SSD 6010 – One Residential Building (Student Accommodation) within Darling Drive

Submission by:

Li Wang

29 July 2013

SHADOW DIAGRAMS: PERSPECTIVE, SHOWING THE PEAK, WINTER SOLSTICE

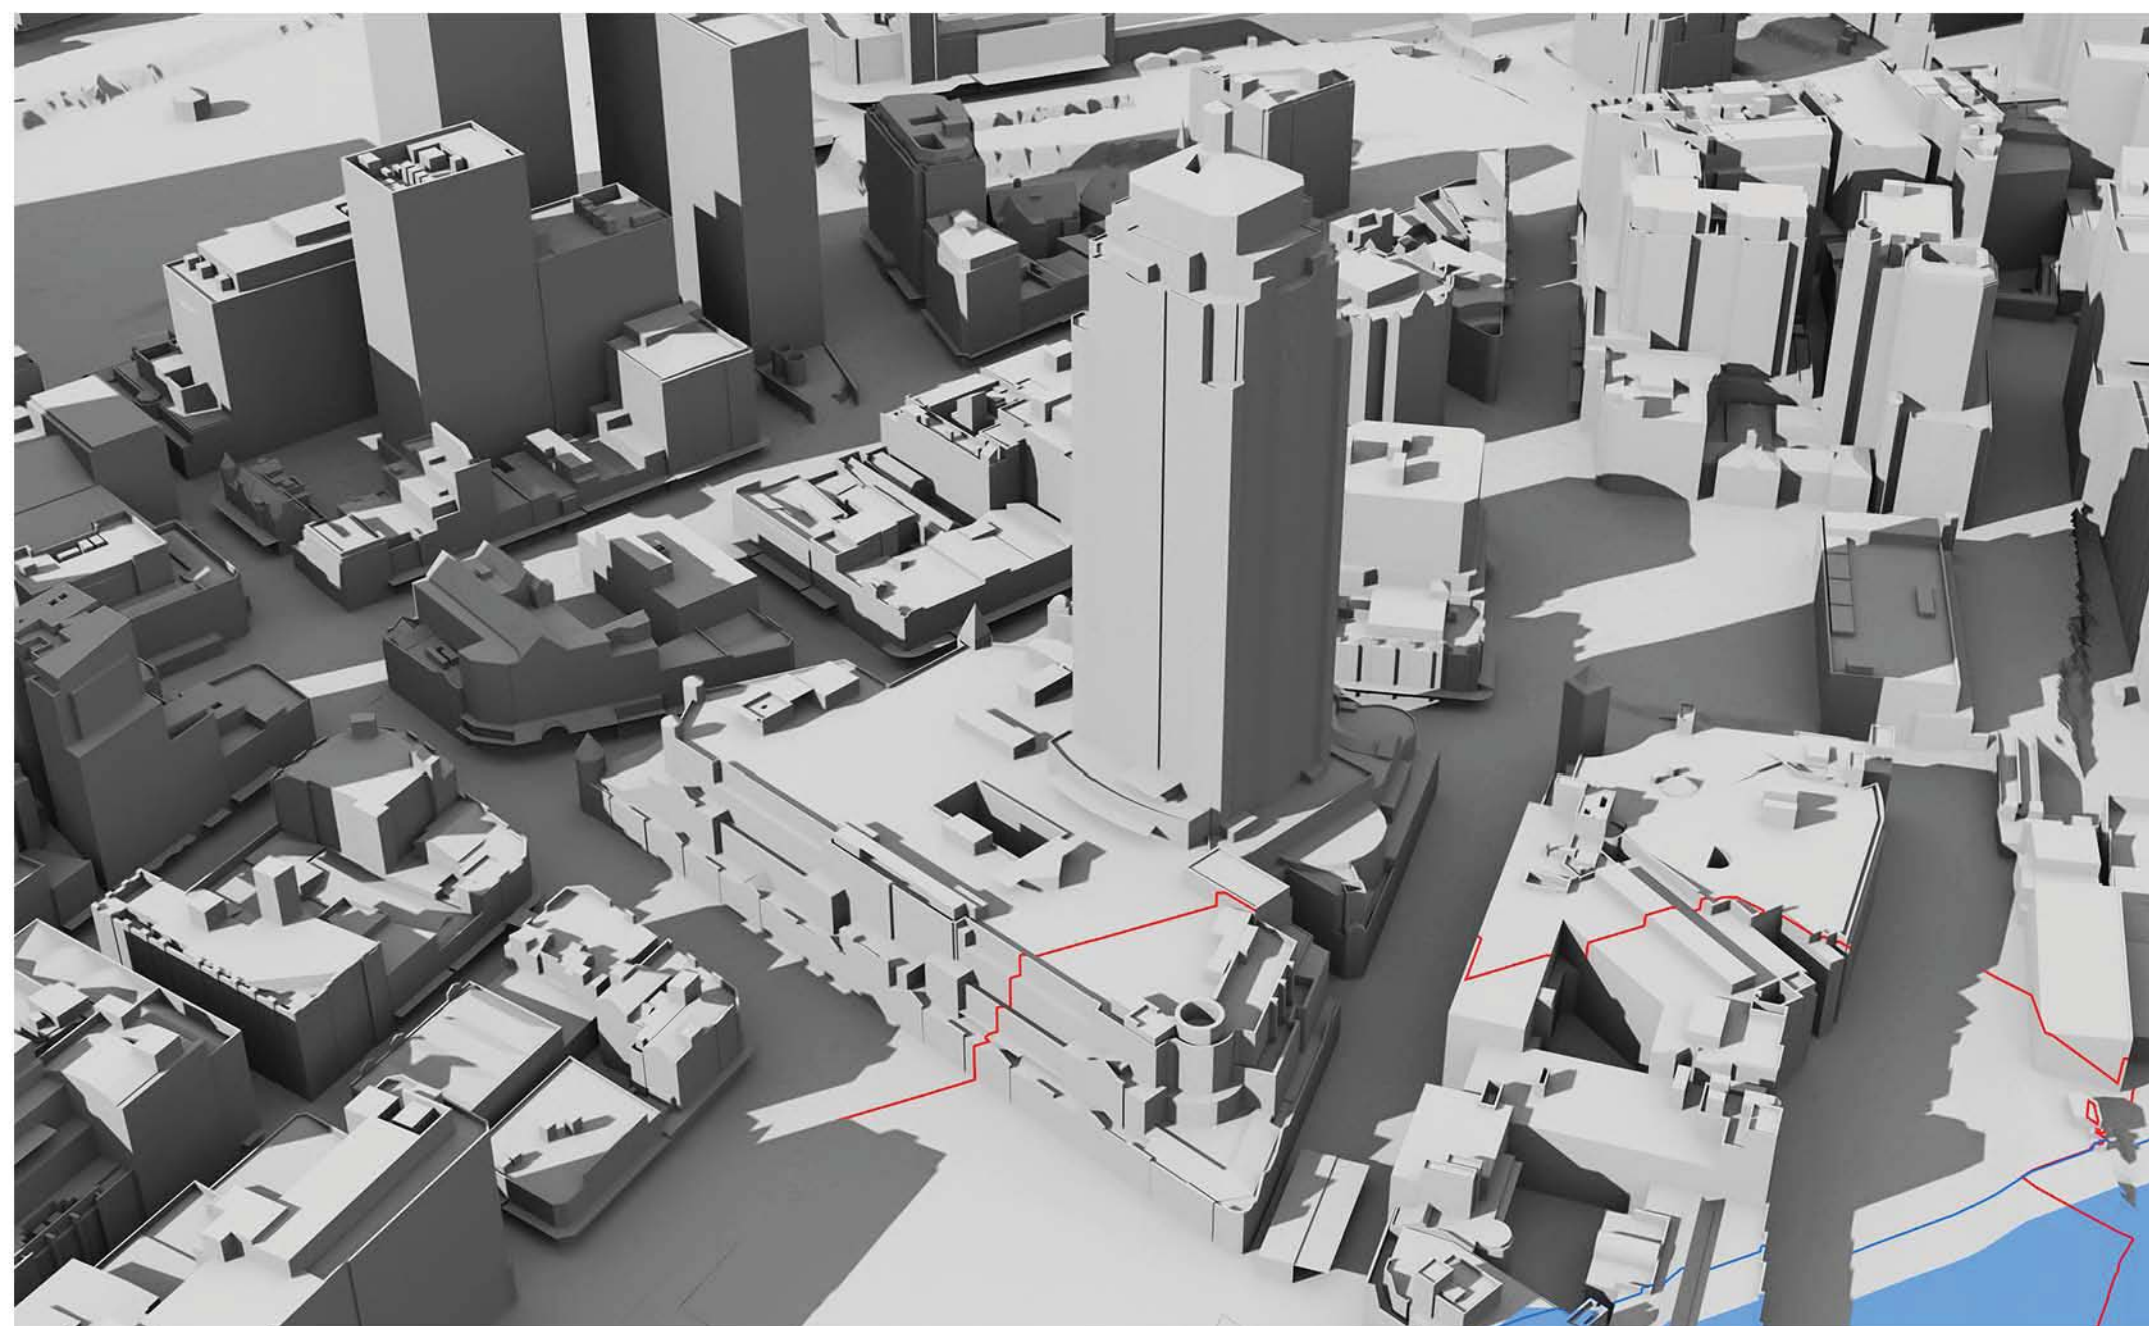
At 9am, 10am and 11am the west façade is totally in shadow due to other parts of The Peak building itself.

At 12pm there is still substantial existing shadowing on the west façade caused by the irregular shape of the west facade.

At 1pm the existing shadowing has been substantially removed, but not totally removed.

It can be concluded that some single aspect apartments on the west façade and some south-west dual aspect corner apartments currently receive less than 2 hours direct sunlight to habitable rooms and 50% of the private open space between 9am and 3pm on 21 June.

By 2pm the existing shadowing has been totally removed, but that is too late to achieve two hours of direct sunlight before 3pm.

At 9am, 10am and 11am the west façade is totally in shadow due to other parts of The Peak building itself.

At 12pm there is still substantial existing shadowing on the west façade caused by the irregular shape of the west facade.

At 1pm the existing shadowing has been substantially, although not entirely, removed. However, overshadowing of lower levels of the west façade by the concept proposal parameter plan shadows for the N,NE and SE plots has already started.

By 2pm the existing shadowing has been totally removed. However, overshadowing of the west façade by the SSDA4 and SSDA5 buildings has appeared and risen further up the west façade than the concept proposal parameter plan shadows for the N,NE and SE plots, which is still present.

At 3pm, the proponent states correctly that 45-45% of the western façade is overshadowed by the SSDA4 and SSDA5 buildings.

It can be concluded that, as a result of combination of the proposed development with existing shadowing of the west façade, some single aspect apartments on the west façade and the south-west dual aspect corner apartments which currently receive less than 2 hours direct sunlight to habitable rooms and 50% of the private open space between 9am and 3pm on 21 June will suffer additional overshadowing. It is beyond our skills to count the number of such apartments. We note that the proponent has made no attempt to do so.

Rather than counting the number of units which will not meet the DCP guidelines, the proponent attempts to trade-off direct sunlight at 4pm for lack of direct sunlight during the period 9am to 3pm. There is no provision in the DCP guidelines for such a trade-off.
